Application ID: S6/2009/1438/FP - Mr D Manhertz Application Owner: Welwyn & Hatfield Borough Council(Development Control Officer)

Location: 46 PLOUGH HILL

Description: INSTALLATION OF FRONT DORMER WINDOW AND AN EXTENSION TO ROOF TO INCLUDE A SIDE DORMER AND FOUR ROOFLIGHTS

Drawing Title
 Proposed Elevations

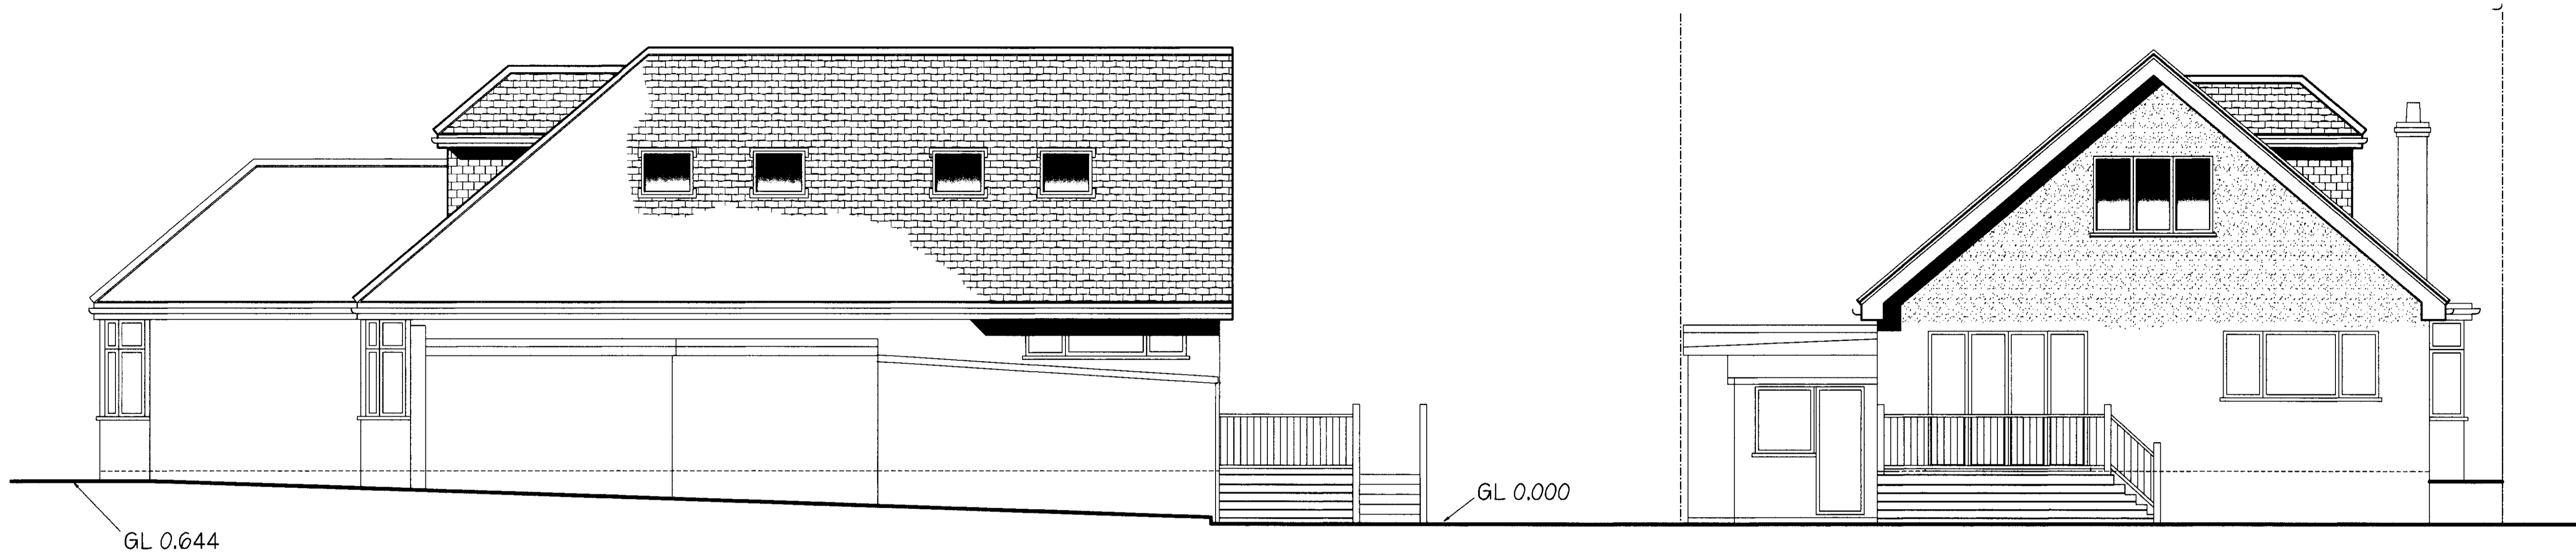
Comment: No objection. But have concerns re side dormer overlooking neighbour
